As per Section 7 of the Department of Planning & Environment's Response to Submissions (attachment B), Mirvac has provided documentation that encapsulates the recommendations and responses for Project '3.1 – Site 53'. Refer to the Design Review Panel (DRP) Advice Sheet. This document summarises the contents of the DRP Advice Sheets.

SOPA Design Review Panel 19.03.15

21 JUNE @ 1500

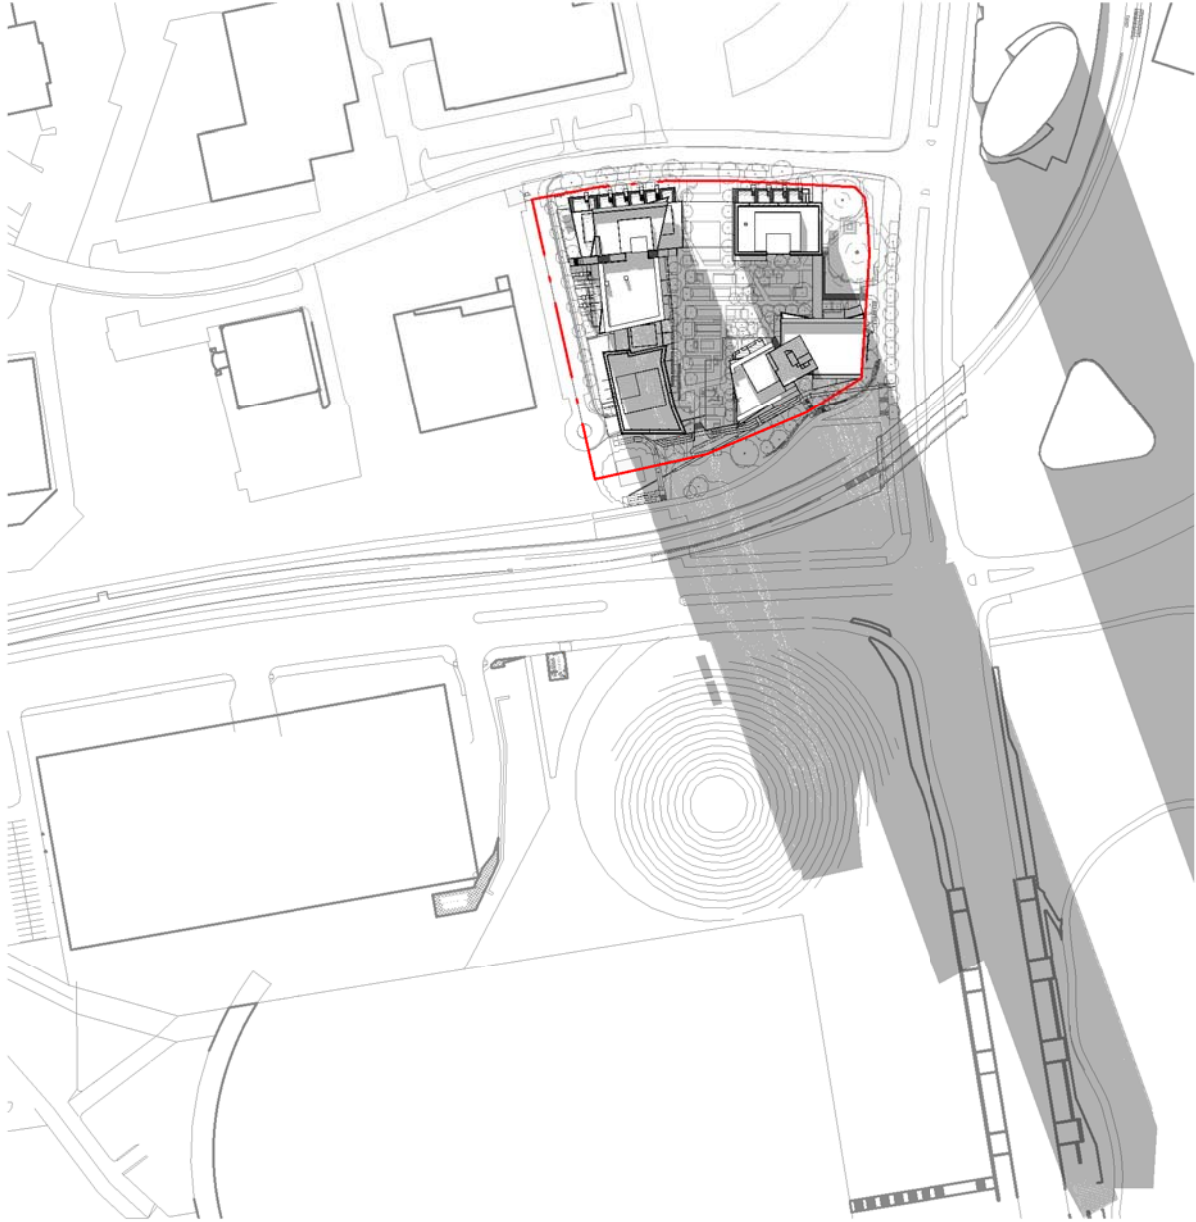
- Large number of units access from each lift will discourage community interaction
- The percentage of units achieving 2 hours sunshine on June 21 has decreased
